**Final Report - Corrections Required**  
**Application No. ANEX-23-0009**

**Description :** A request by Norris Ranch Joint Venture, LLC, for annexation of 1.224 acres into the City of Colorado Springs. The annexation is a part of the overall Karman Line Land Use Plan, which is being submitted concurrently. The Land Use Plan proposes a maximum of 6,500 dwelling units, approximately 45 acres of light industrial, 105 acres of commercial/retail, 100 acres of mixed-use development, and 570 acres of park/open space.

**Document Filename :** Plat

# ANNEXATION PLAT KARMAN LINE NO. 1

ANNEXATION PLAT, KARMAN LINE NO. 1
A PORTION OF THE NE1/4 OF SECTION 11,
TOWNSHIP 15 SOUTH, RANGE 65 WEST OF THE 6TH P.M.,
COUNTY OF EL PASO, COLORADO

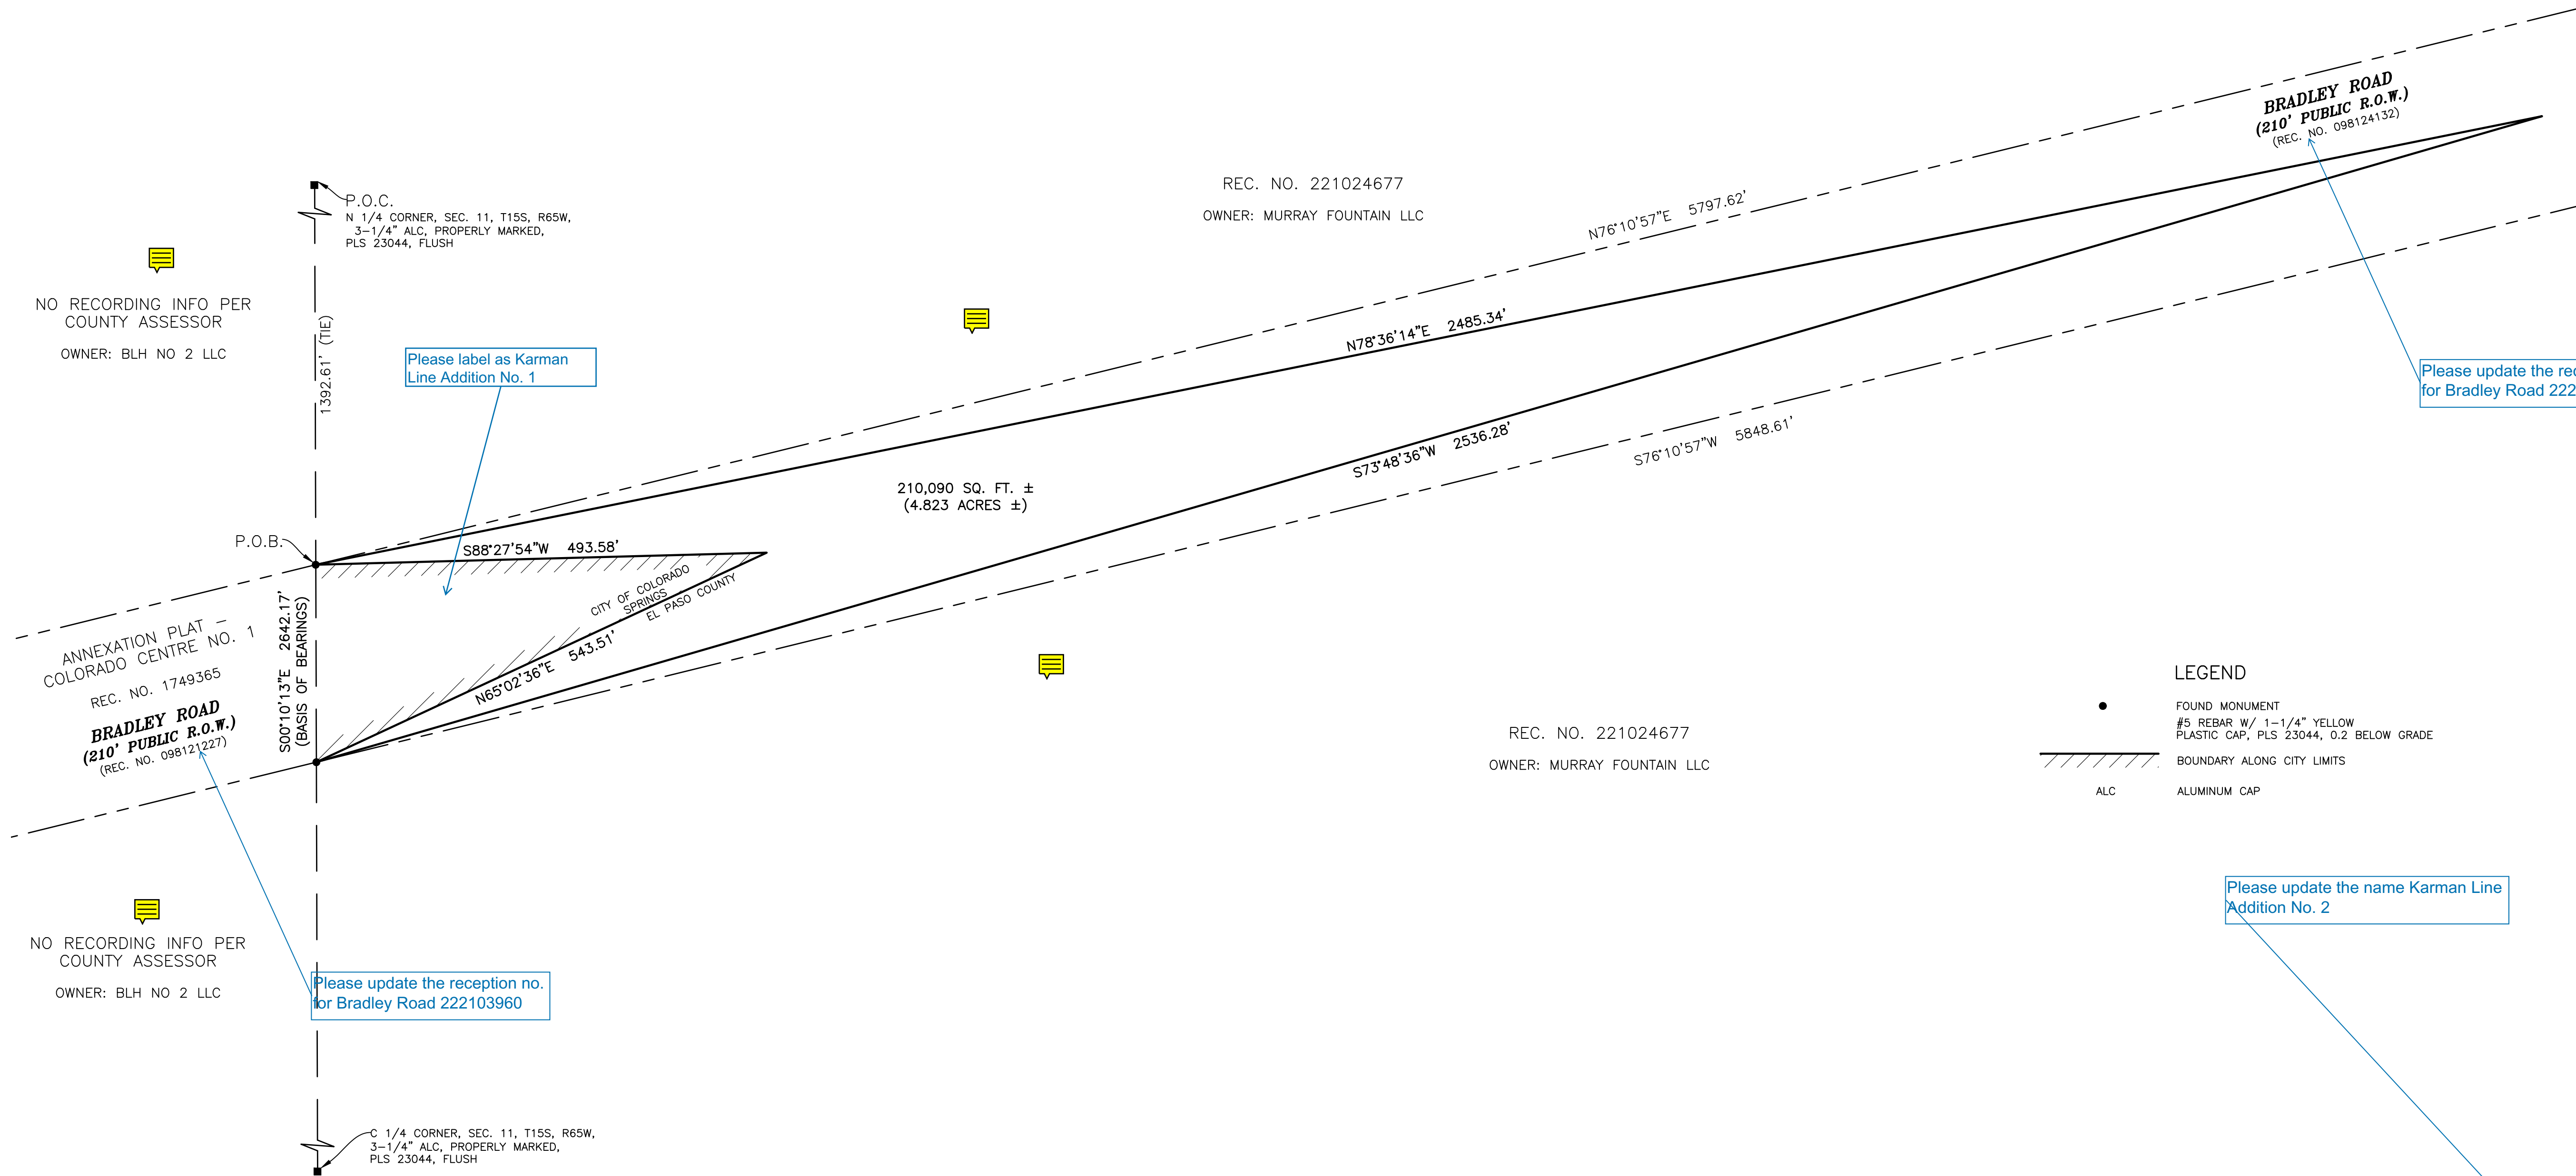
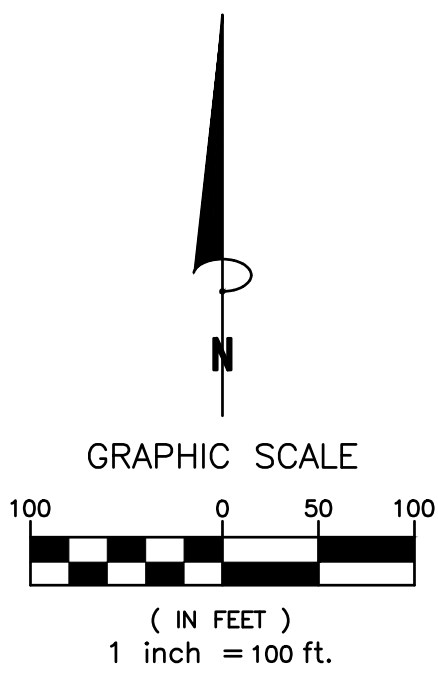
27	1	Dan Sexton : Planning	Please provide a separate drawing for this annexation so compliance with the City's Water Ordinance can be confirmed.
28	1	Dan Sexton : Planning	The land associated with this annexation request appears to be part of the Rolling Hills Ranch Metro District. Prior to public hearing scheduling, the documentation must be provided to show that the roadway is not part of the district or has been deannexed.
